BEECROFT CHELTENHAM CIVIC TRUST INC

BULLETIN 4

Special Issue - Epping to Thornleigh Third Track Oppose this Project which will destroy Beecroft and Cheltenham A Submission Form for you to sign is on Page 4

What is wrong with the Epping to Thornleigh Third Track (ETTT) Proposal

Figure S.5 Artist's impression of new elevated concourse at Cheltenham Station looking south from The Crescent (indicated by dot)

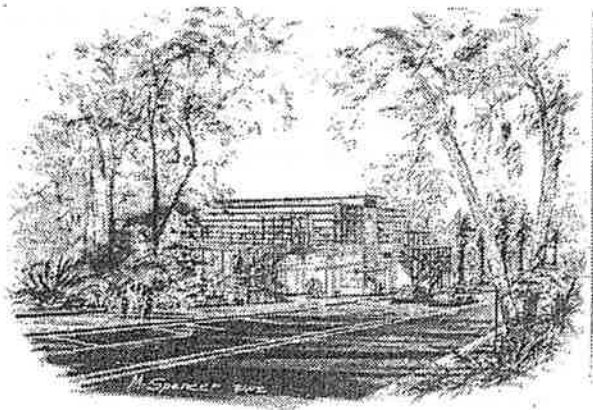
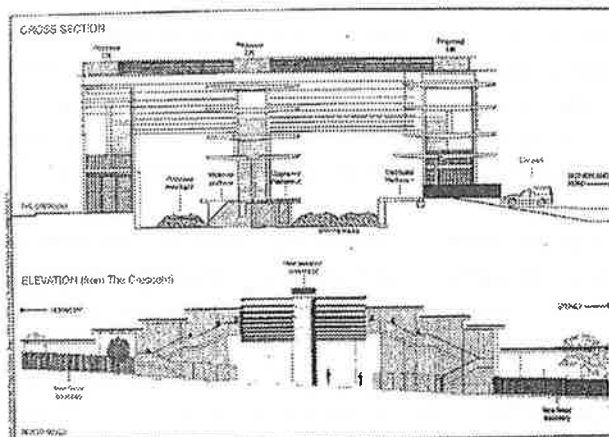
The ETTT proposal imposes a two storey, 13m high, railway concourse at Cheltenham to be positioned near the entrance to the current car park. It will have lift and stair access to all platforms, a bus bay and taxi rank. The indicative design shown in the EIS is a glass and steel structure. This is totally inappropriate for a Heritage Conservation Area and indicates that the designers either ignored or were unaware of the HCA. The only time buses come to Cheltenham Station is when they are replacing rail. There has never been a taxi rank at Cheltenham, nor any need for one.

The EIS considers that this huge structure is *'unlikely to have significant impacts on the heritage values'* of the houses opposite, mainly because some of them will be screened by vegetation.

Figure 5.3 Future Cheltenham Station layout

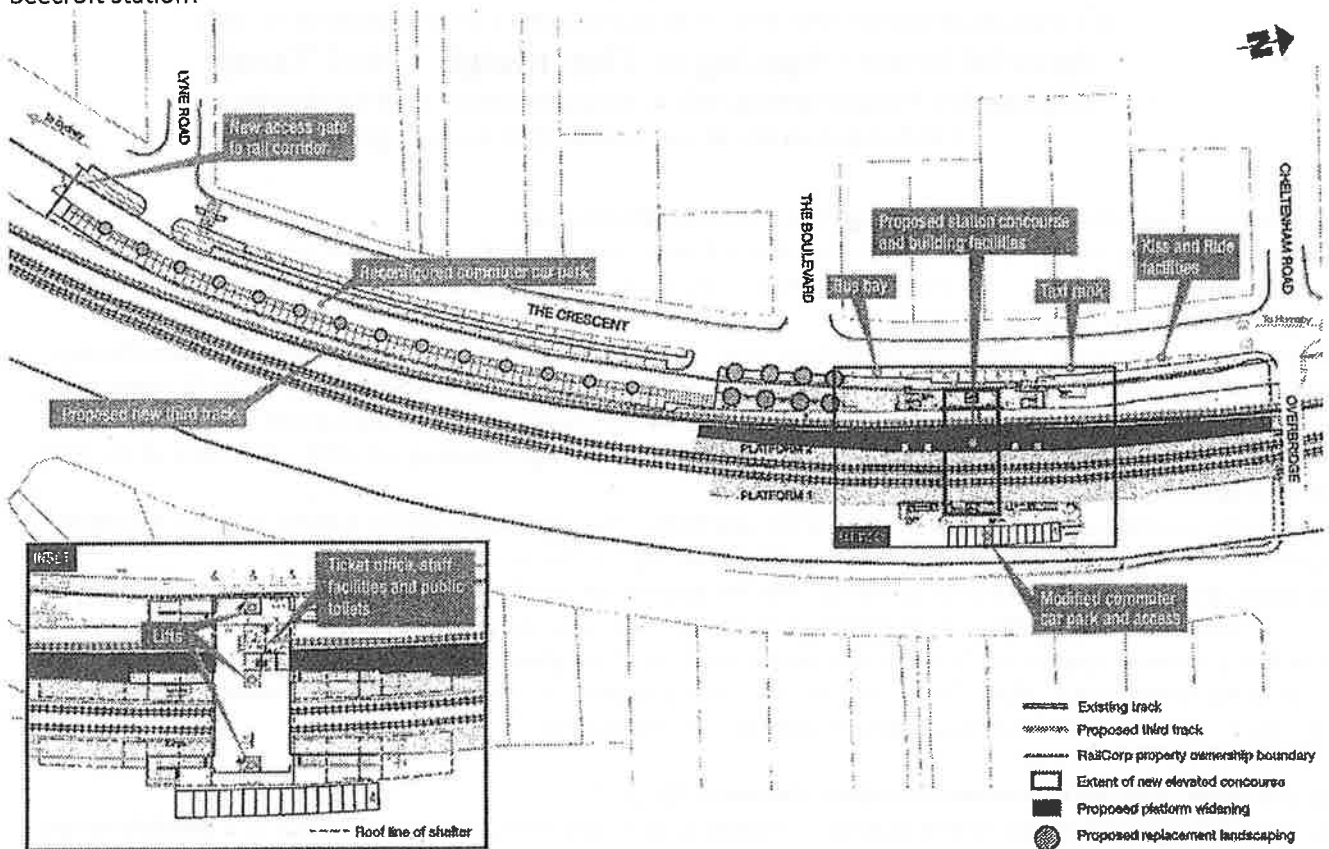
The car park on the western side will be extended almost to Lyne Road which will increase walking distance and impact on the Cheltenham Recreation Club. Parking in The Crescent adjacent to the station is removed.

Rock will be removed from the cutting under the western side of the road bridge which will be strengthened.

Why is this work proposed for such a quiet station when little enhancement is proposed for the much busier Beecroft station?
